## **Frodsham Solar**

### **Environmental Statement: Volume 2**

#### **Appendix 4-6: Response to Sections 2.1 and 2.2 of the Scoping Opinion**

PINS Ref: EN010153

Figure Title  
**Indicative Construction Compound and Access Track Layout**

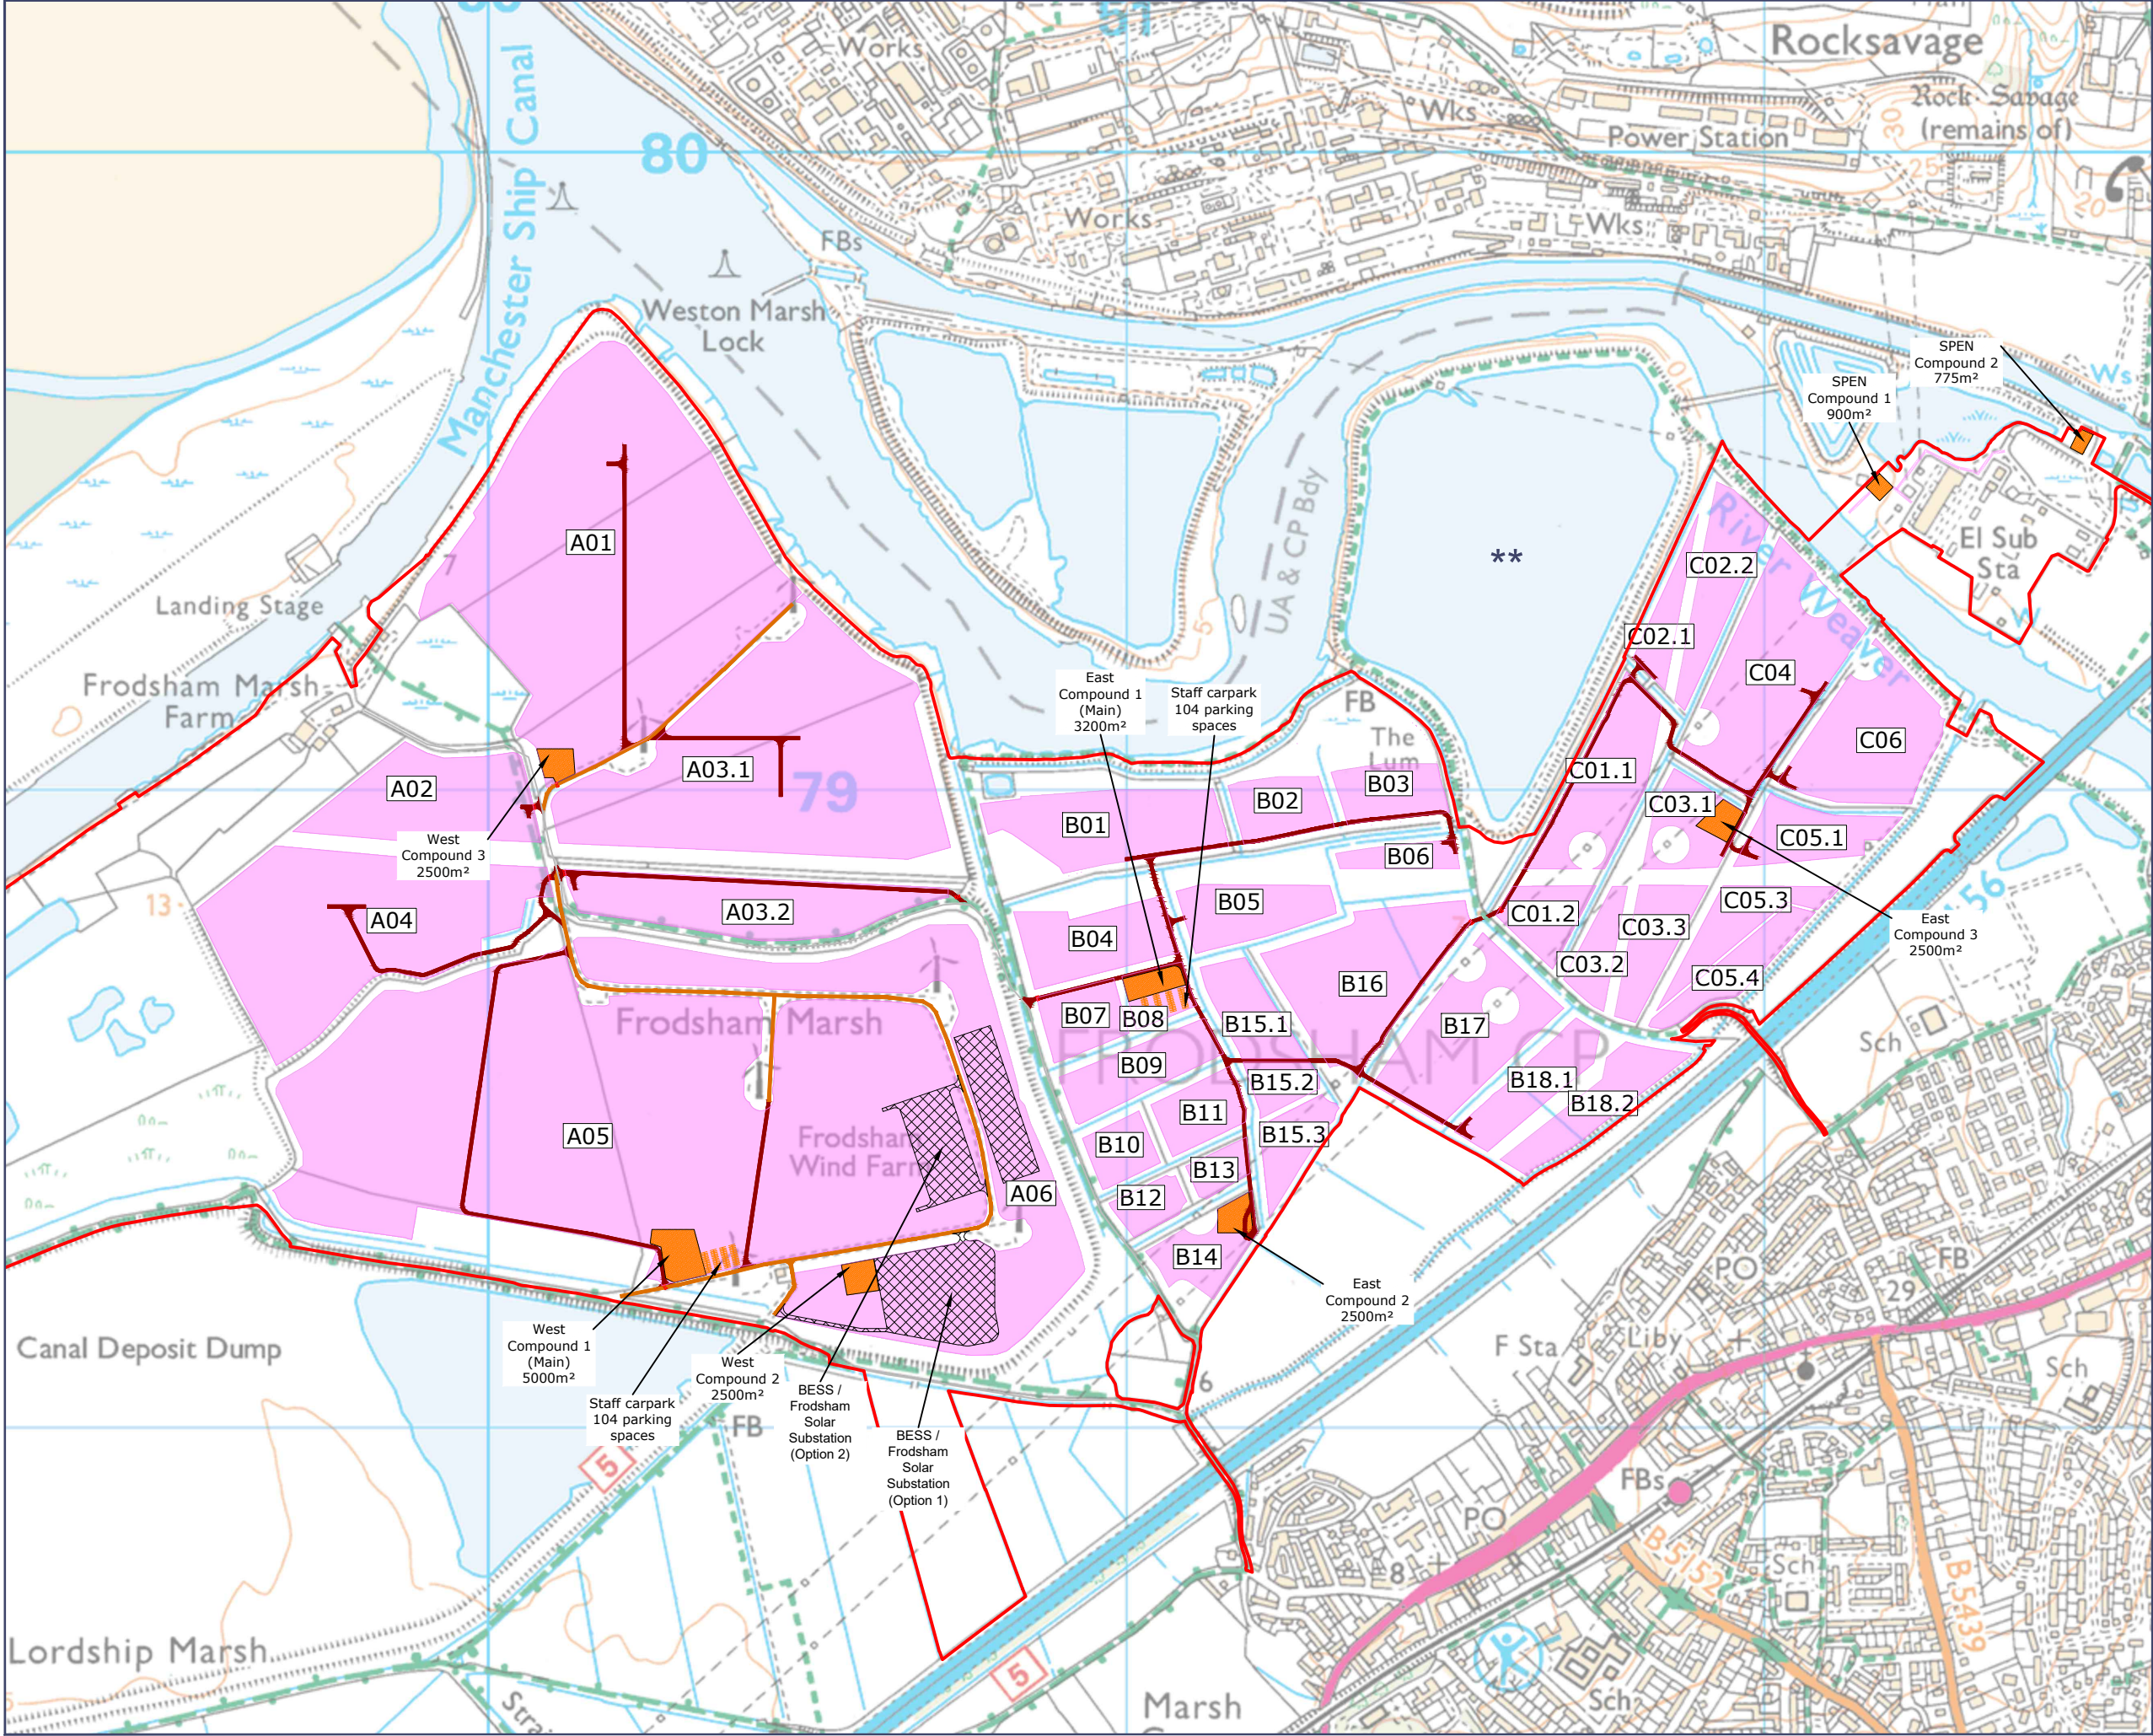
2.1.2	Paragraph 16.2.2 of the Scoping Report describes works required to provide connections and access. As drafted, it is not clear as to whether works may be required outside the solar array development area or the redline boundary. Furthermore, the Scoping Report at present has been found to not consistently include connections in proposed assessments, the ES will be required to ensure that the full Proposed Development has been assessed. The ES should clearly set out the location of all works or where uncertainty remains, assess the worst-case scenario.	The access points to the Site and the grid connections proposed are fully described within <b>ES Vol 1 Chapter 2: The Proposed Development [EN010153/DR/6.1]</b> and these routes have been assessed within the technical assessments contained in the ES.

2.1.4	<p>The Scoping Report states that one or more temporary construction compound(s) will be required as well as temporary roadways to facilitate access to all land within the site and that at present, it is anticipated that all temporary land requirements would be able to be included within the boundary shown on Figure 1.2 of the Scoping Report.</p> <p>The number, location and maximum parameters of construction compounds and temporary roadways should be identified in the ES. The ES should explain how the optioneering process for such development components has sought to avoid or minimise impacts on environmental receptors during construction and operation.</p>	<b>ES Vol 1 Chapter 2: The Proposed Development [EN010153/DR/6.1]</b> describes the construction compounds and access roads proposed, including the design parameters of these elements to enable a reasonable worst case assessment to be undertaken. The measures adopted to minimise impacts on environmental receptors have been described.
